Subject: RE: EP/64/19/DOC

1. Please provide further details of the shallow swale, i.e. bed level and bank levels.
2. Diffuser units are located closer than 5m to buildings.
3. Please provide updated construction detail drawings.

Drawing No: X:\PROJECTS\4501_Marmont_EastPreston\Plans\4501_Marmont_EastPreston_DrainageLayout.dwg

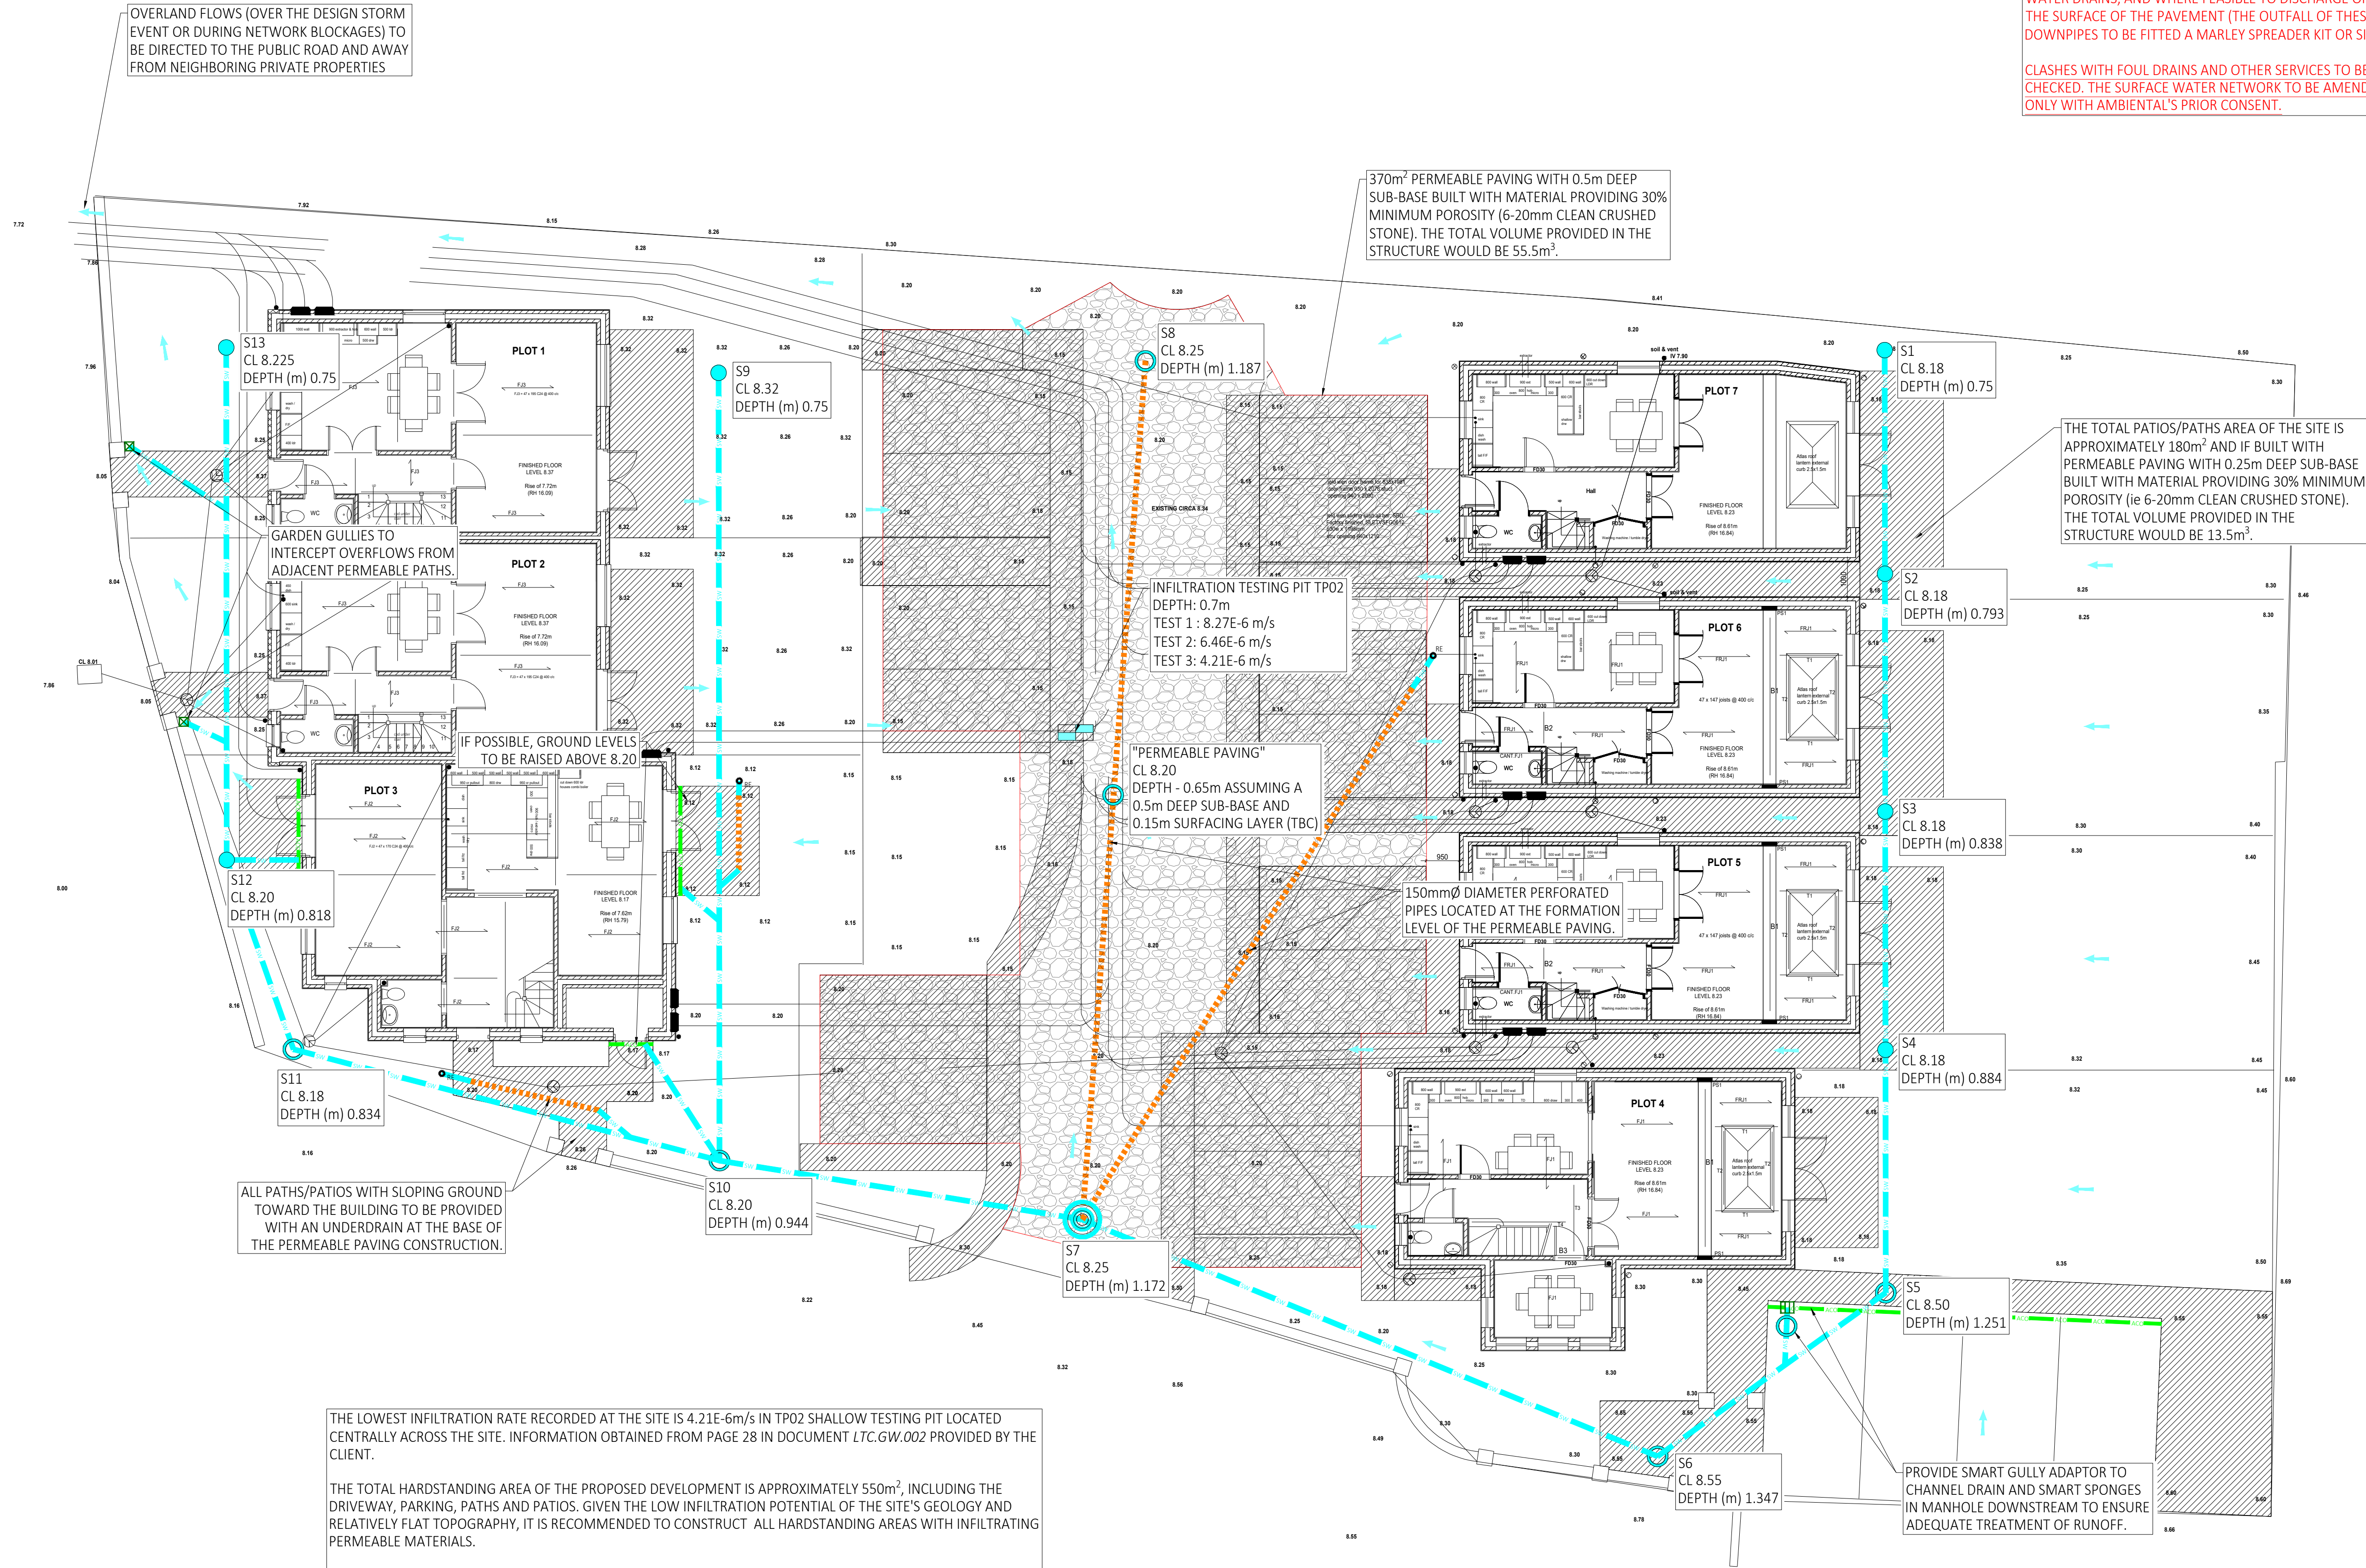
Switching diffuser units for perforated pipe isn't sufficient. Infiltration should not occur within 5m of a building when the infiltrating structure is dealing with more water than that which is falling directly on it.

1. Layouts need to clearly identify the formation and finish level proposed for permeable paving. On drawing & section detail
2. Please can invert levels and not depths be expressed at each manhole. Added
3. The size and fall of all pipes needs to be clearly labelled on the plan. Added
4. Catchpit locations need to be clearly marked on the plan. Added

5. The factor of safety used in calculations needs to be revised to be compliant with requirements set out within CIRIA. Please refer to our checklist for further information on this. Used CV=1 and FoS = 3, this increased storage with approx. 30%. Added a geocellular tank to the side of the pavement in the soft landscaping to make up for it, see section detail on drawing.
6. Please can an impermeable area plan be provided. in link
7. Please can pipe numbers used in calculations be provided on the layout to facilitate my review. Added
8. The invert level of the permeable paving modelled is incorrect. Please can a cap volume depth also be modelled. Used 0.418m cap to reflect the attenuation storage throughout the site, both in the 0.5m and 0.25m deep regions - $(55.5\text{m}^3 + 13.5\text{m}^3) / ((370\text{m}^2 + 180\text{m}^2) \times 0.3)$
